Application for a non-material amendment following a grant of planning permission.

Number	
Suffix	
Property name	Bronlea
Address line 1	The Street
Address line 2	
Address line 3	
Town/city	Walberton
Postcode	BN18 0PG
Description of site location must be completed if postcode is not known:	
Easting (x)	496978
Northing (y)	106068

First floor extension to East over existing garage, ground floor extension to South, and detached garage in front garden.

Reference number:	WA/37/20/HH
Date of decision	18/08/2020

DRAWING TITLE
**Location & Block Plan
PLANNING ISSUE**

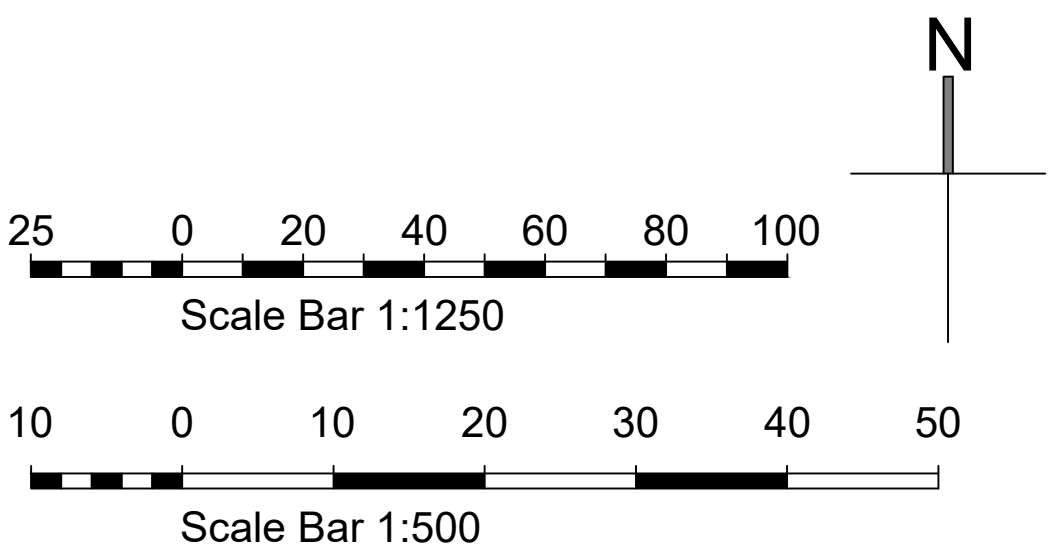
Move location of new, detached garage further away from site West boundary

To allow maintenance access to rear (West) of new garage.
